From: Contact Centre (CRM) <contact@ribblevalley.gov.uk>
Sent: 06 October 2024 11:38
To: Planning
Subject: Planning Application Comments - 3/2024/0585 FS-Case-652403507

Planning Application Reference No.: 3/2024/0585

Address of Development: 3 Church St, Clitheroe

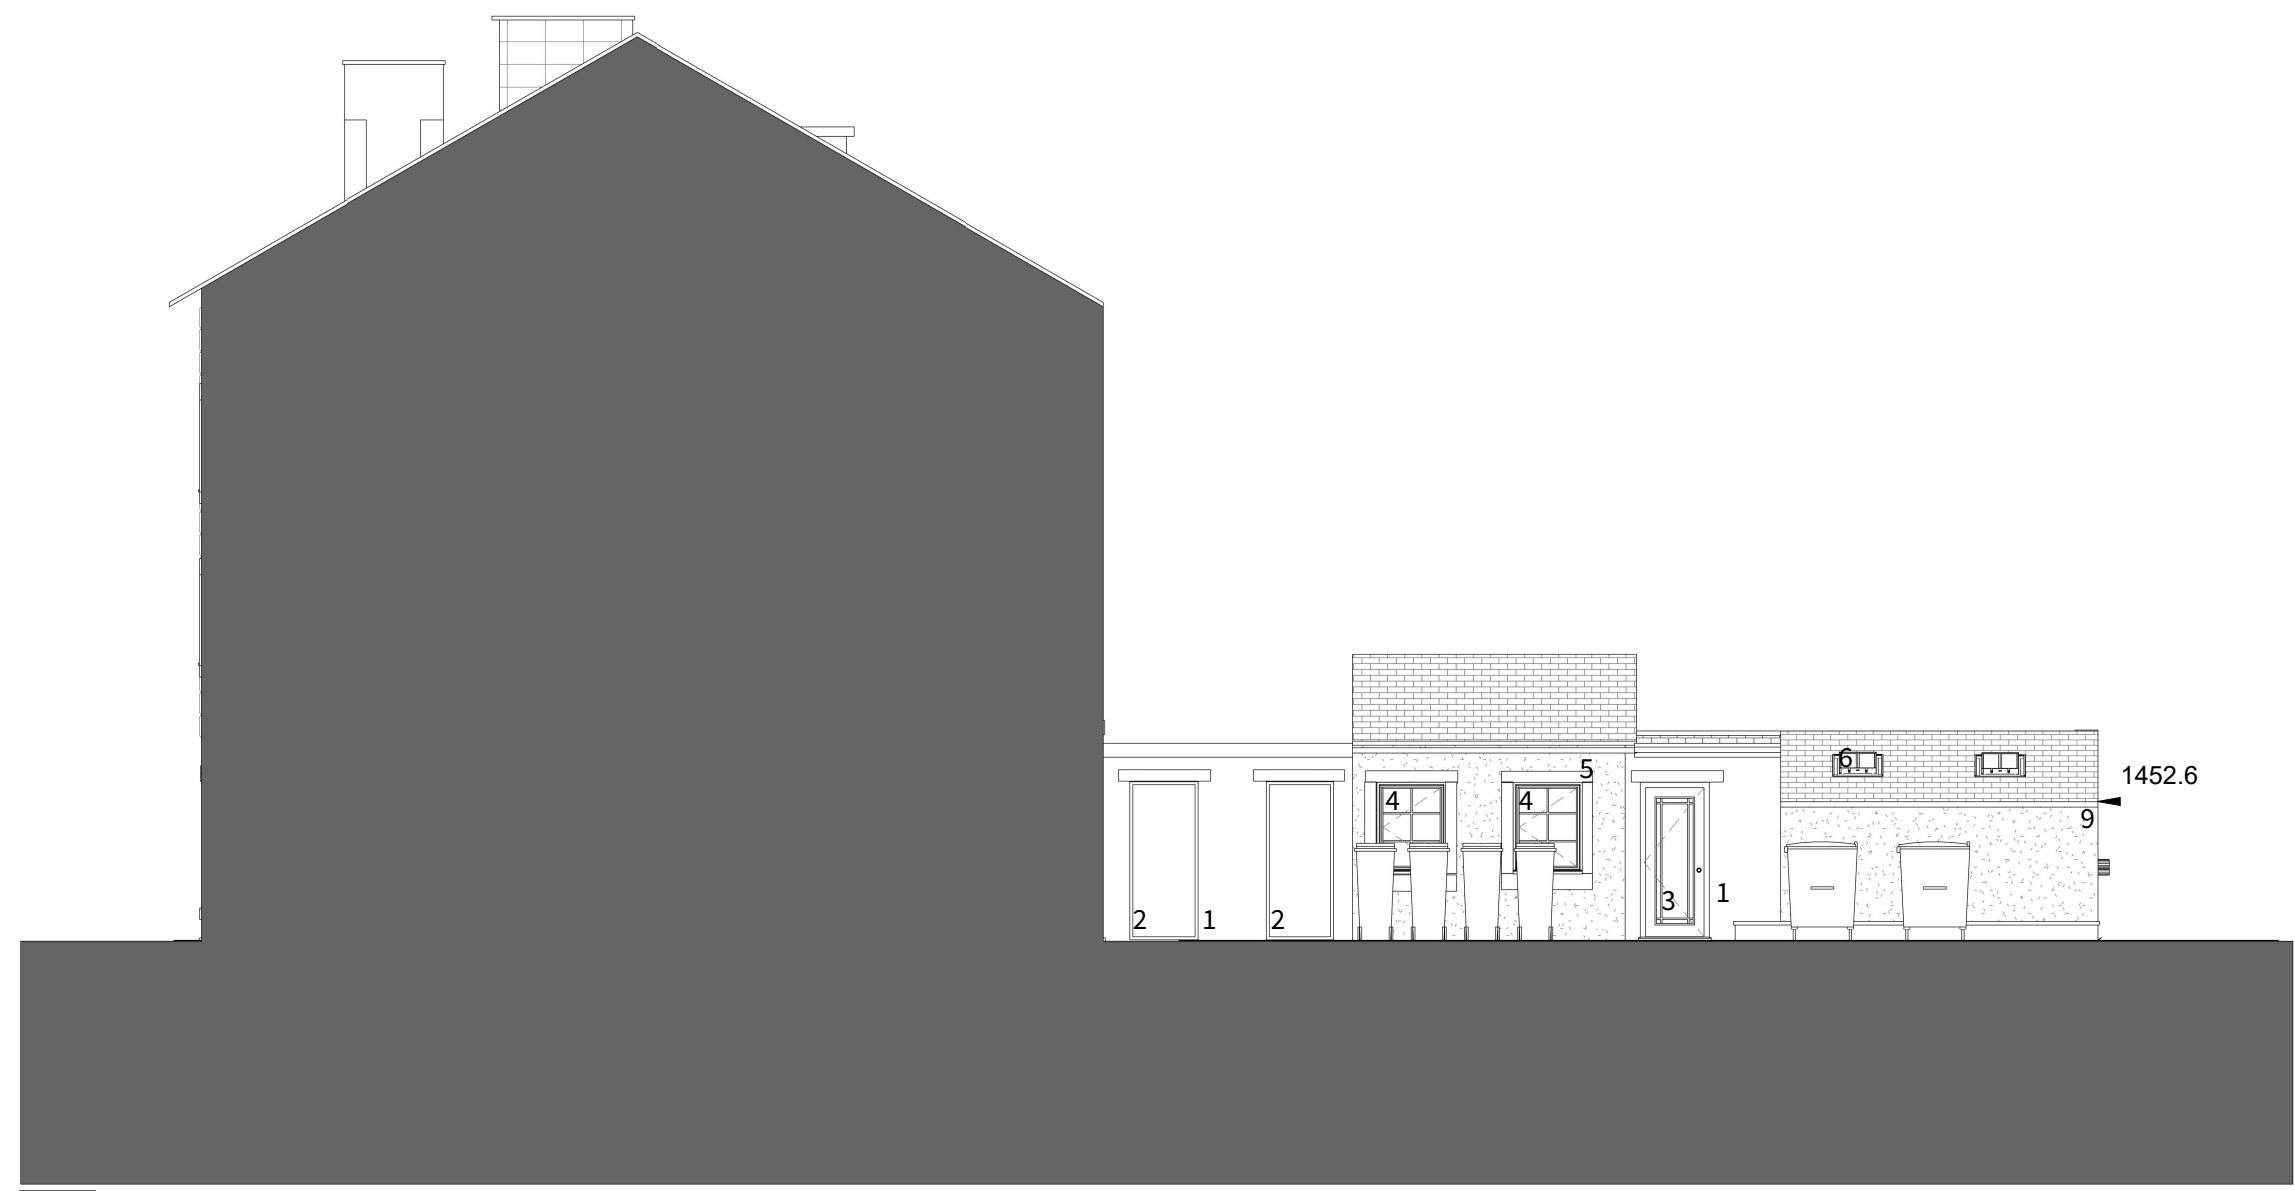
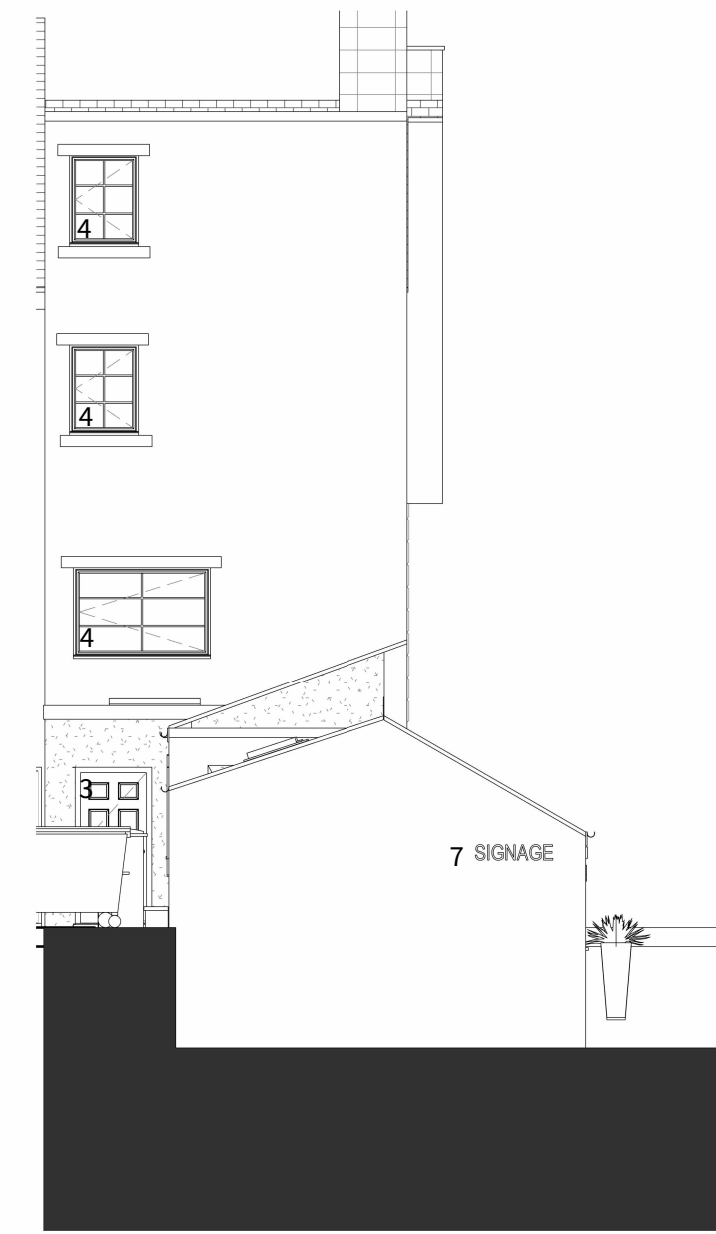
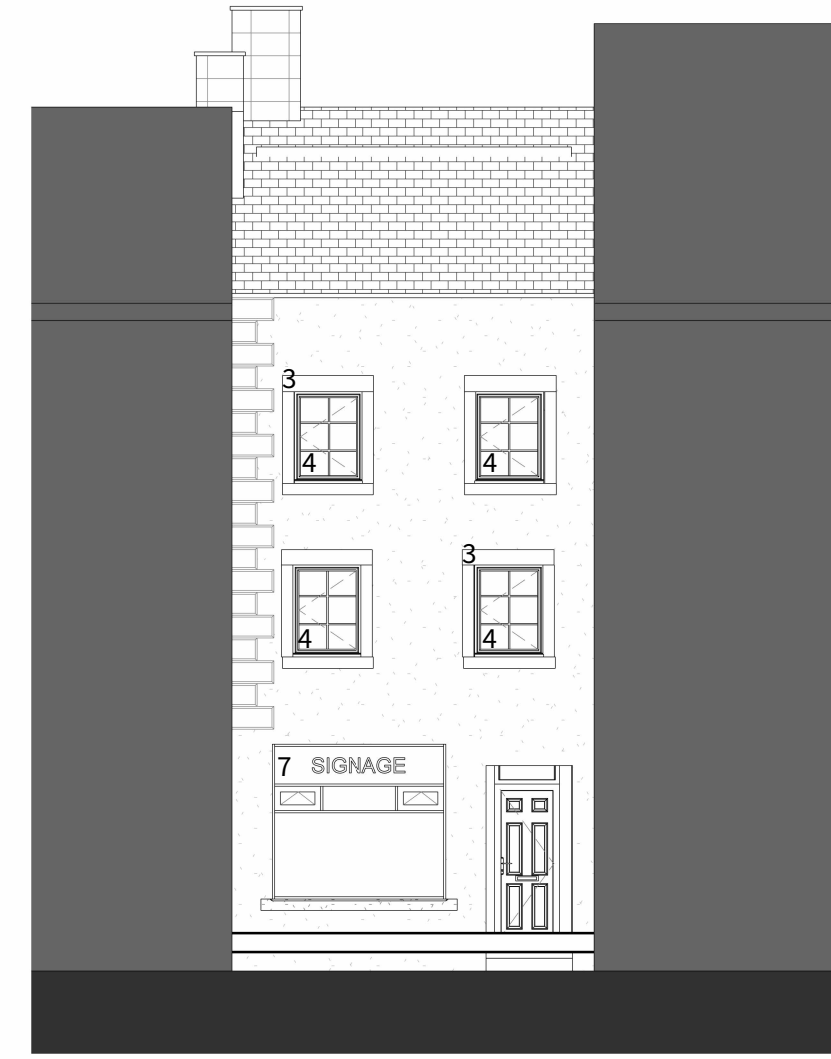
In our opinion, the conversion of the garage to a retail unit, with new signage etc and an entrance from White Lion passage, will be harmful to the character and appearance of the conservation area. This building was originally a store or stabling, and has not historically been a shop. The view towards Church Street from the council car park through White Horse passage is very characterful due to the survival of undeveloped ancillary buildings like this, and to develop these buildings so obviously would be harmful to the significance of the listed building and the conservation area. We also noticed that this building would be partially re-roofed, altering the profile of the gable end.

We do not think that upvc windows and doors are appropriate, in any part of the proposed development. There is a precedent for upvc being unacceptable in this area, as demonstrated by the unauthorised replacement of timber windows with upvc at the rear of 1 Church Street a few years ago <https://webportal.ribblevalley.gov.uk/planningApplication/31559>. The intention to replace historic timber windows with similar ones is welcome, however there is no condition survey to demonstrate why these window frames need to be replaced at all. It's possible that they could be repaired and restored, which is preferable to replacement as more historic fabric can be retained. In addition, painting the frames and stone surrounds in black is not in keeping at this location.

1 Working-Plan_00-Ground Proposed
1:50

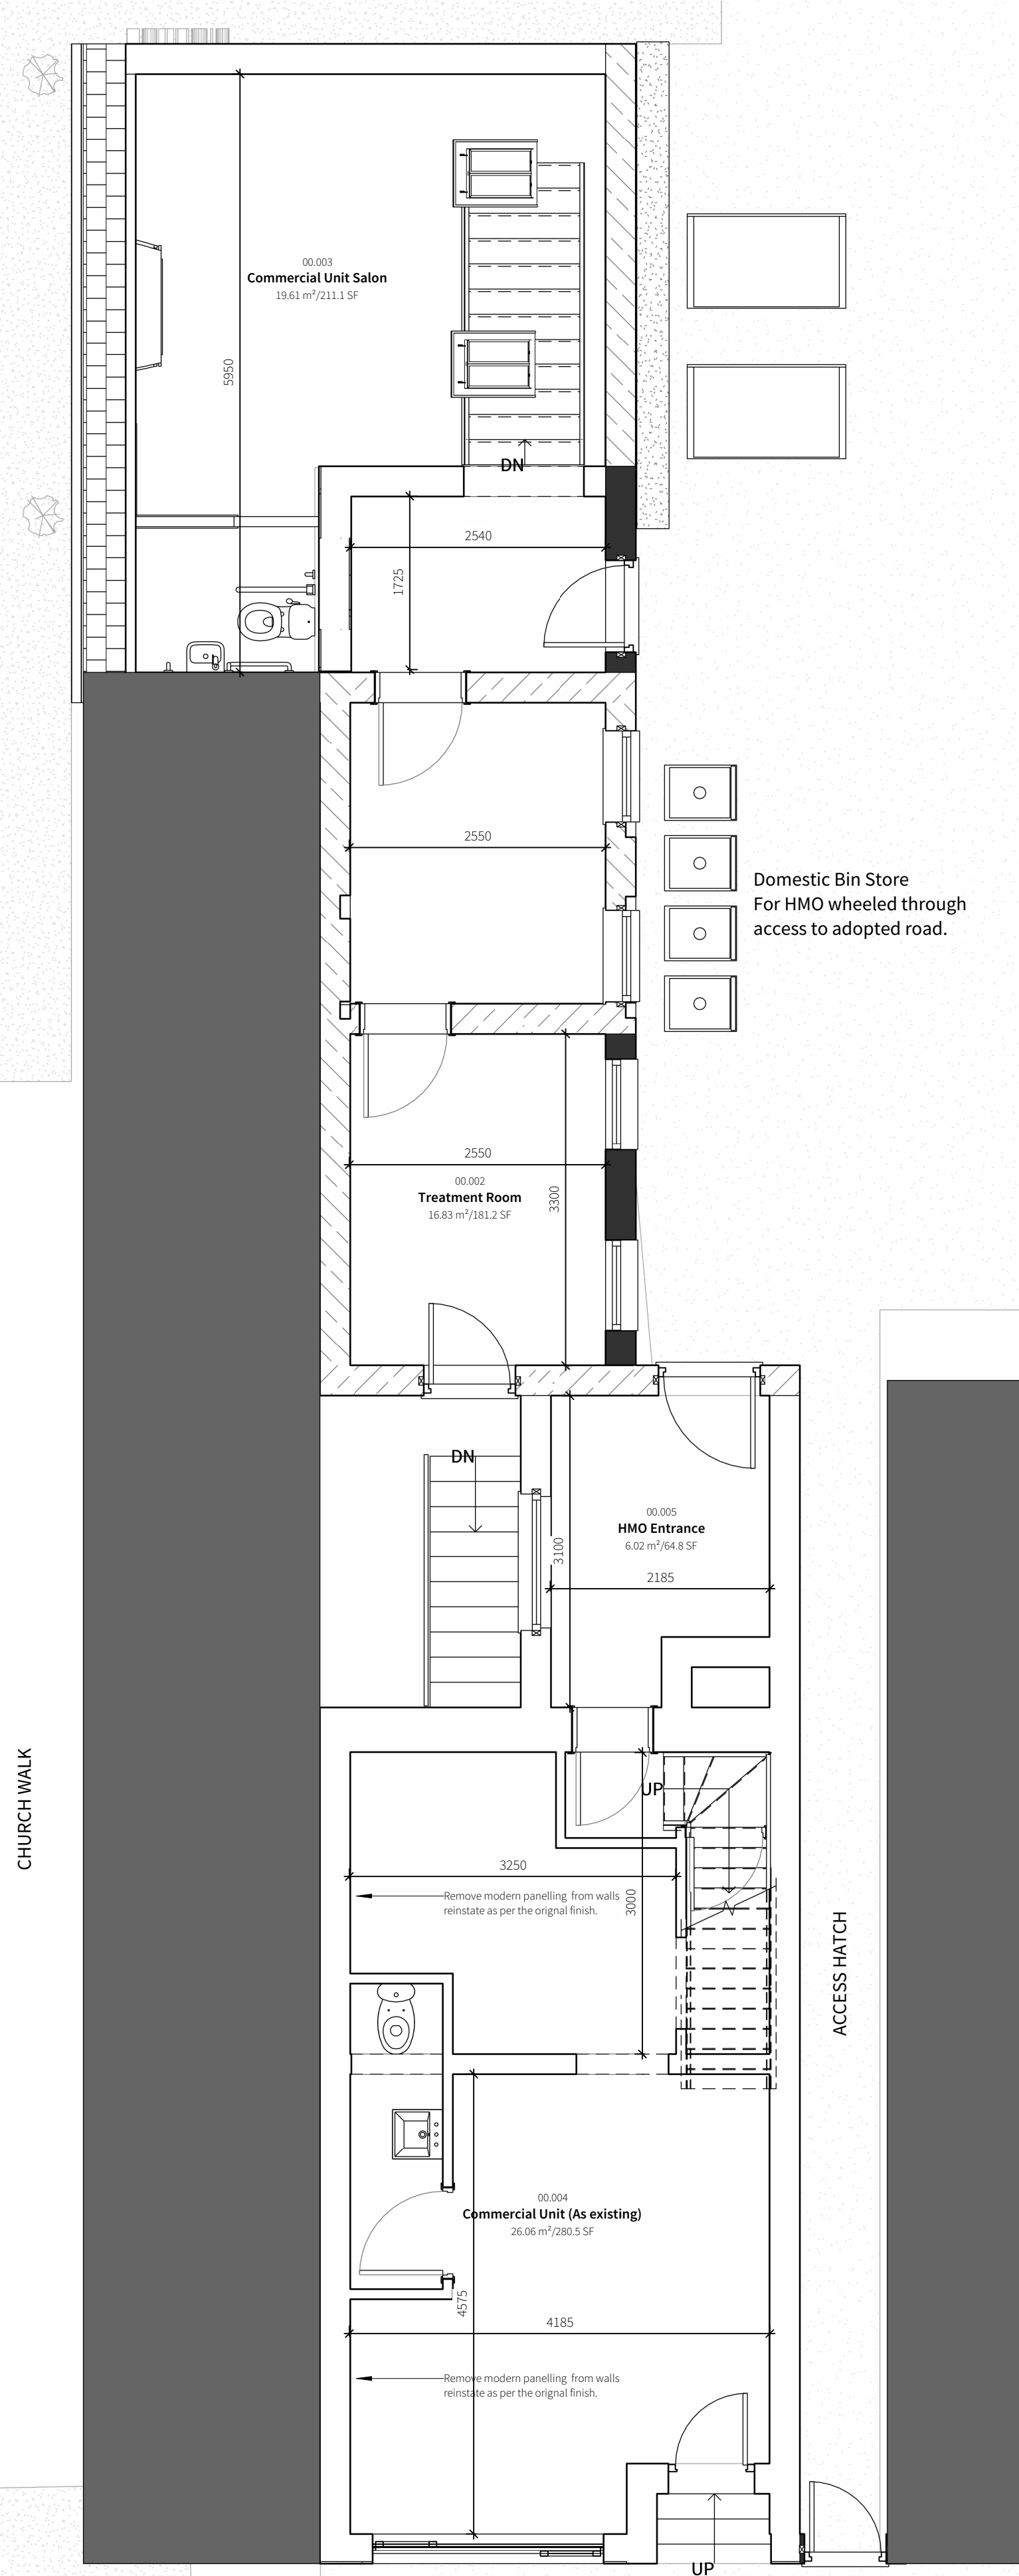
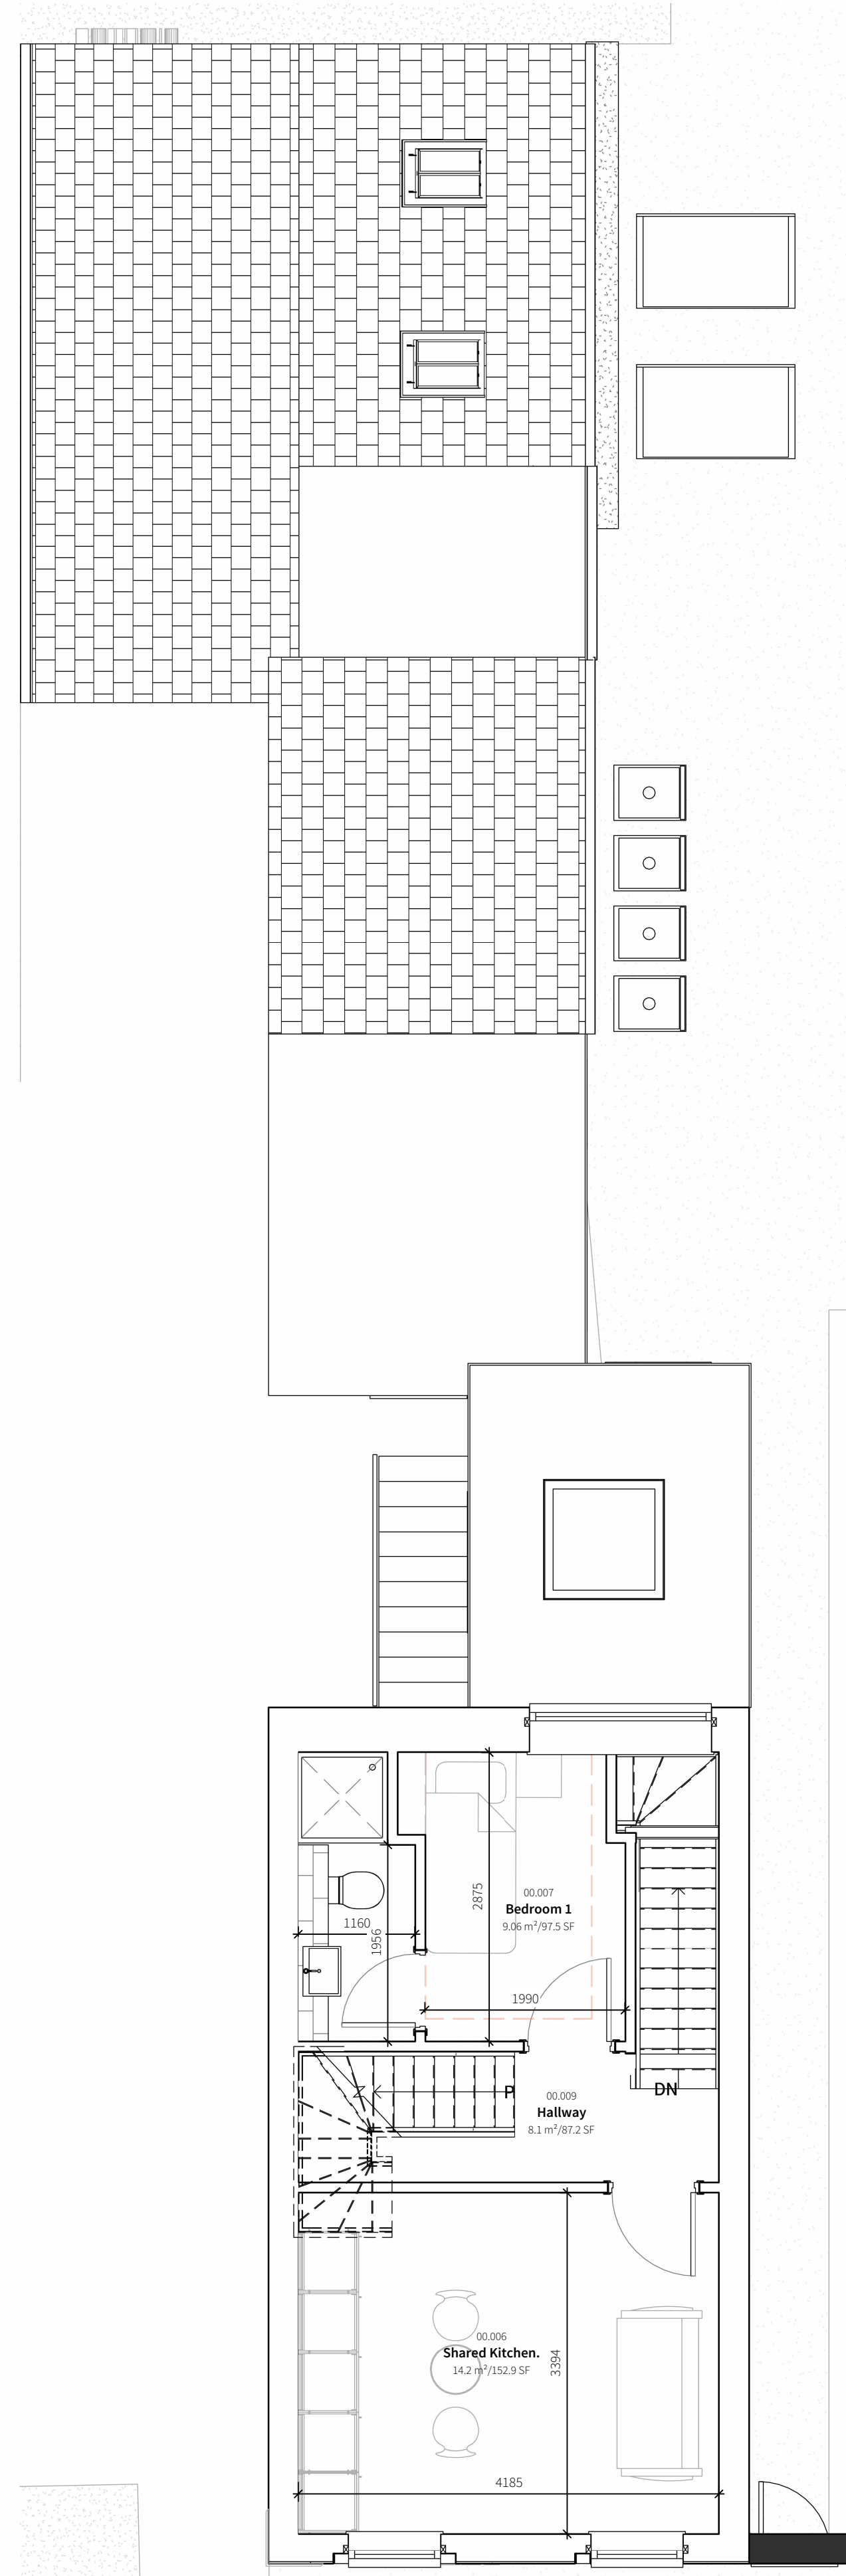
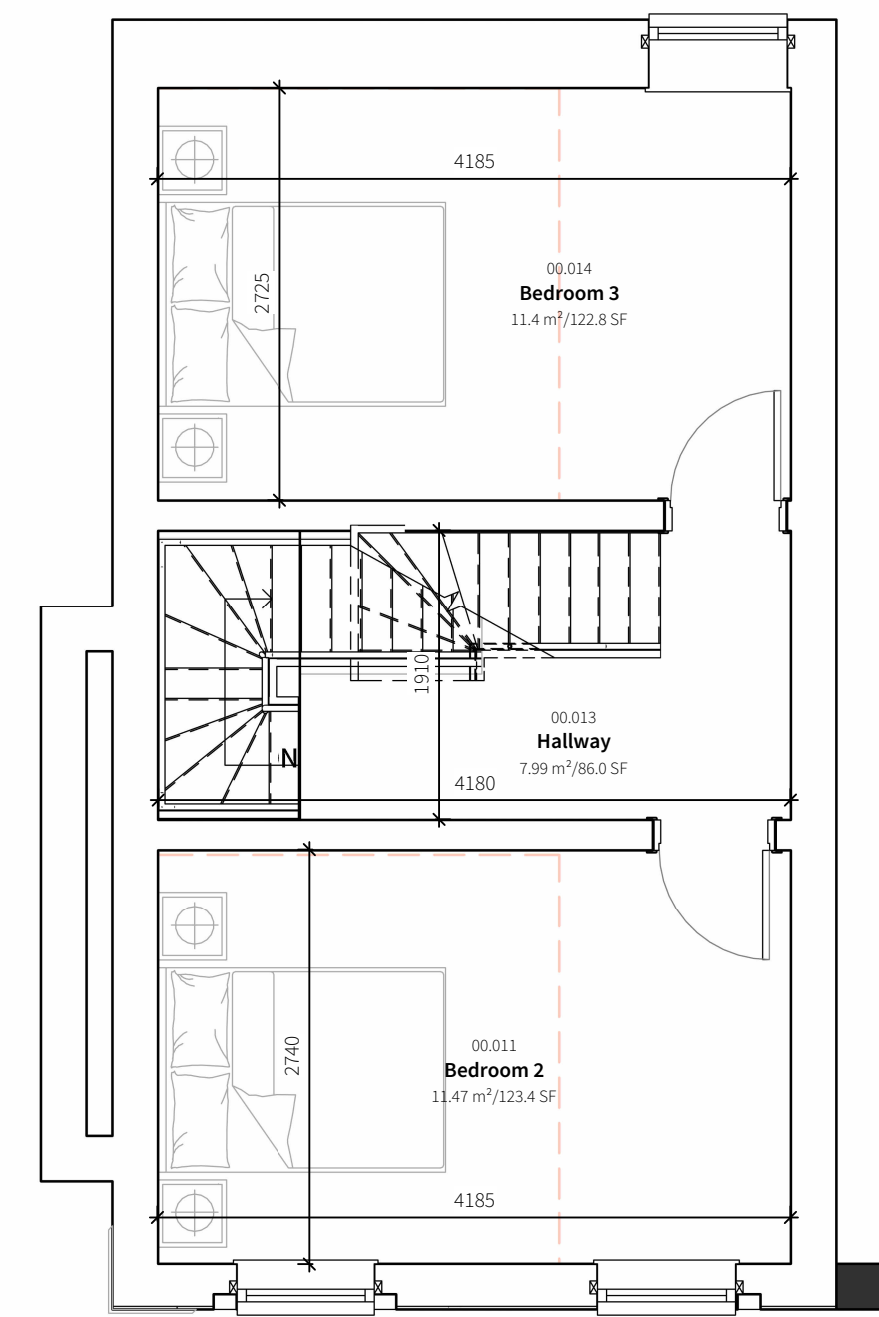
The buildings to the rear (labelled 'store' and 'garage' on the submitted existing site plans) are potentially very old, at least mid-19th century. The existing plans show what seems to be a substantial fireplace in the store building, which is absent from the proposed plans therefore presumably being removed. There are no photos of this in the application so we can't assess its significance.
